KD:kd

17th June 2016

**Re: Supplementary Submission to the State Significant Development Application and Variation of the Sydney Cove Redevelopment Scheme:
'Remediation, Renewal and Adaptive Reuse of Campbell's Stores, The Rocks' (SSD 7056)**

01 WEST ELEVATION
SCALE: 1:200

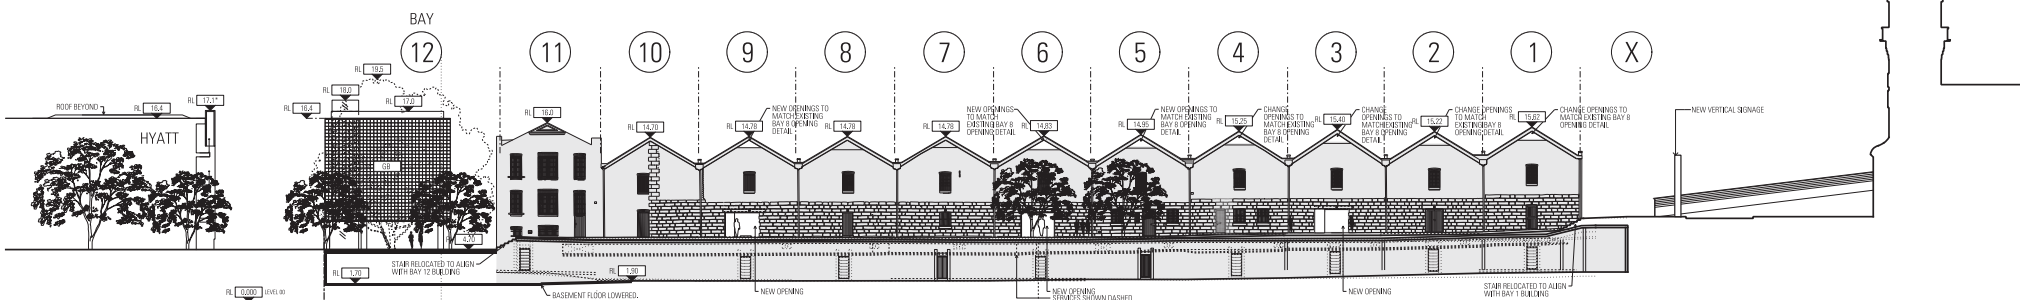
Our previous objection in relation to proposed changes to the western elevation of the Campbell Stores building still stands. Campbell's Stores is of 'Exceptional' significance and Policy 1 of the CMP (GML, 2014) states: *The future use of Campbell's Stores should be consistent with its*

The proposed works to the Hickson Road façade not only will result in widening the existing openings they will also introduce new, concrete entry portals incorporating signage. These works should not be approved as they will have a major impact on the significance of the place, dramatically altering the character of the western elevation of the Stores building and introducing non-reversible intrusive elements into a building of 'Exceptional' significance.

The Hickson Road façade is the only elevation at the place that is not cluttered or obscured by later additions and features related to the current uses of the place (i.e. restaurant signage, canopy structures, the intrusive pavilion and the southern brick wall). As such, the retention and maintenance of this elevation as a simply detailed, functional elevation with no further alterations or additions is critical to the conservation of the significance of the place as a whole.

Given that door openings that are capable of providing for public access as required by the current proposal already exist in this western elevation, further alterations and loss of original fabric as proposed, does not appear to be justified.

We concur with the comments made by the Heritage Council of NSW submission letter (dated 10th February 2015) which states that: "The new doorways in Bays 3, 6 and 9 of the west façade propose the removal of significant fabric and addition of new contemporary awnings in three locations that would diminish the architectural character of the west façade from Hickson Road to an unacceptable level" (Item No. 1).

Scale: 1:100
 Section: SECTION-BAY 3

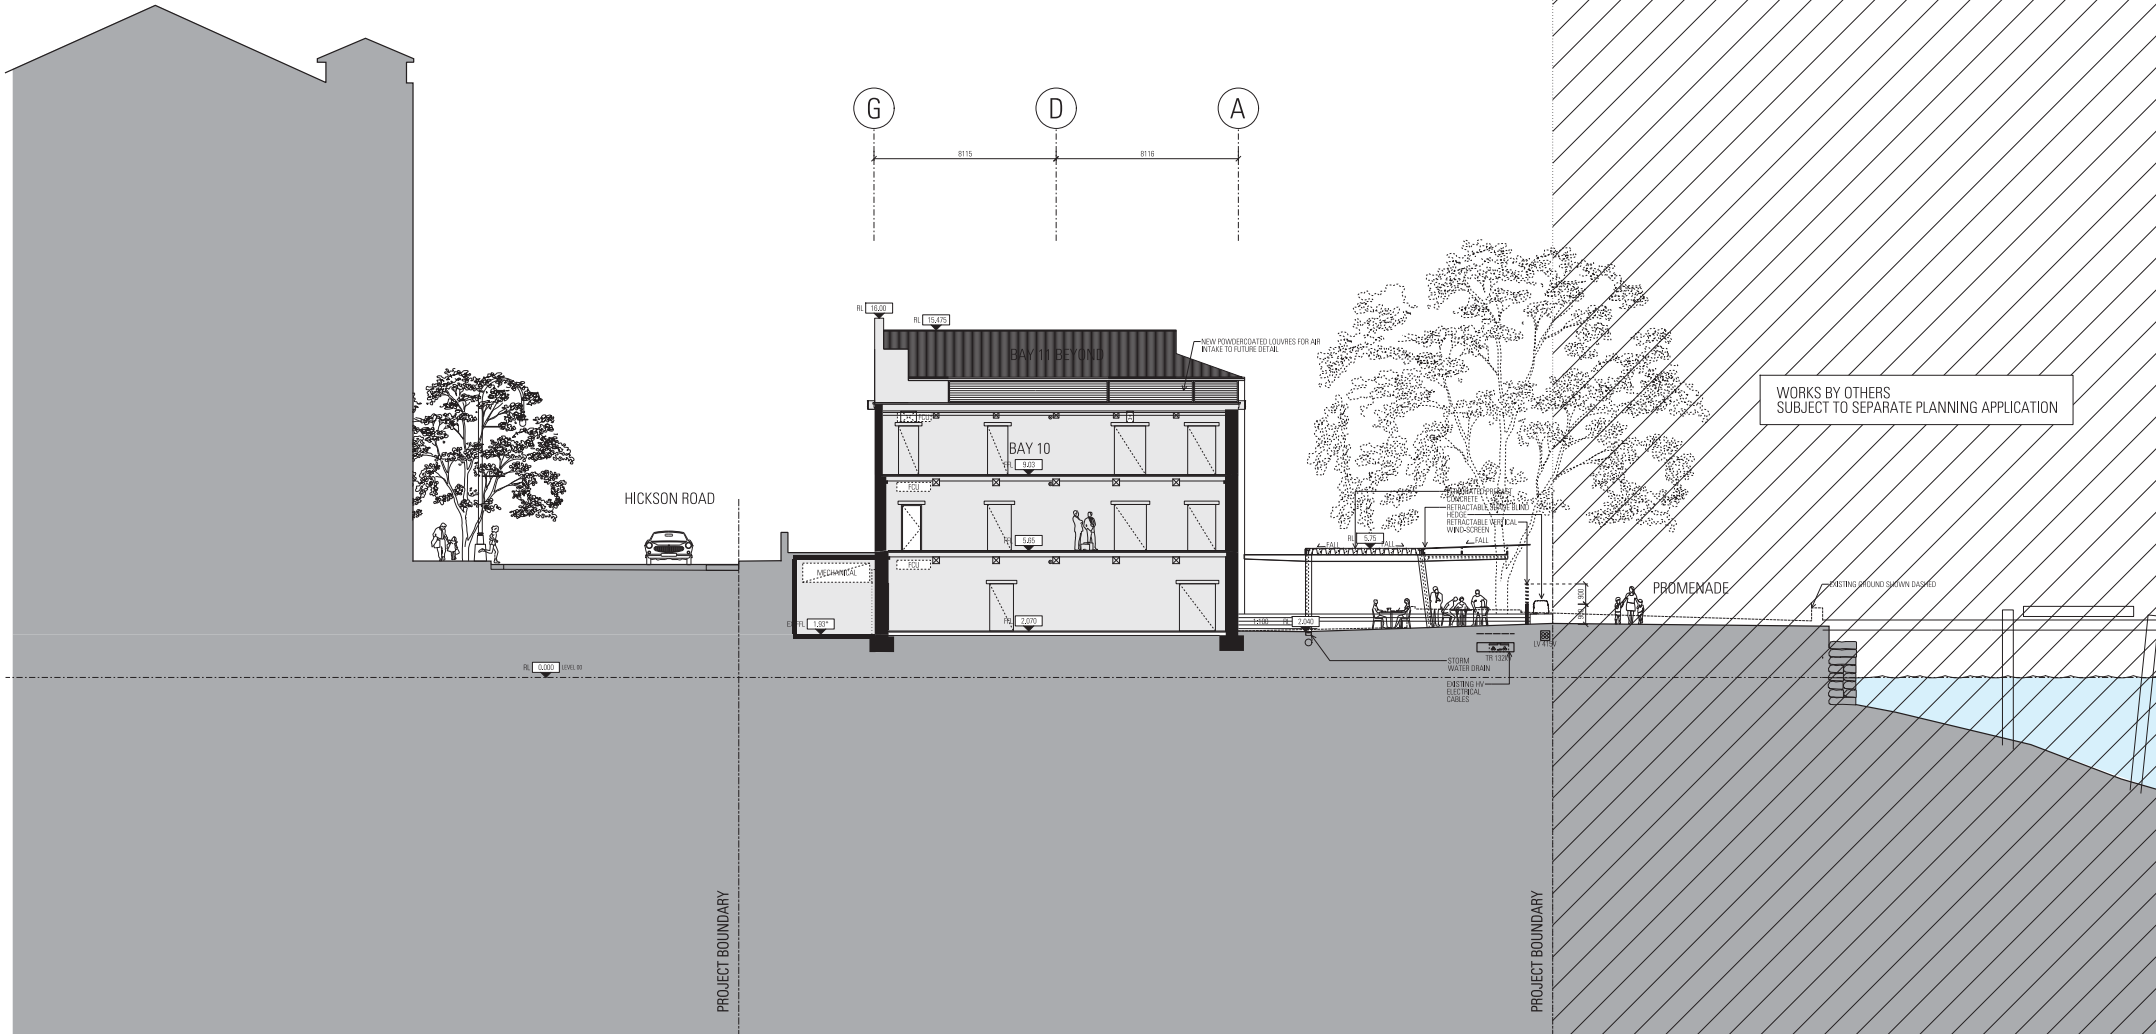
Following our review of the amended architectural plans (Section Bay 3- EA-A-3003/B), our previous objection to the form and details of the proposed new eastern awnings still stands. Specifically, the potential impacts of the retractable vertical wind screens along the eastern edge of the forecourt have not been addressed within the 'Response to Submissions' documentation. Based on our assessment, the design for the new canopy/shade structures and the new wind screens do not comply with CMP Policy 13 or the detailed guidelines for sympathetic, replacement structures (contained within the CMP):

The proposed new canopies also retain perforated precast concrete roofs that are neither visually permeable nor transparent and will interrupt clear views of the whole of the eastern elevation by introducing a solid, built structure running horizontally across the principal elevation of the Stores building.
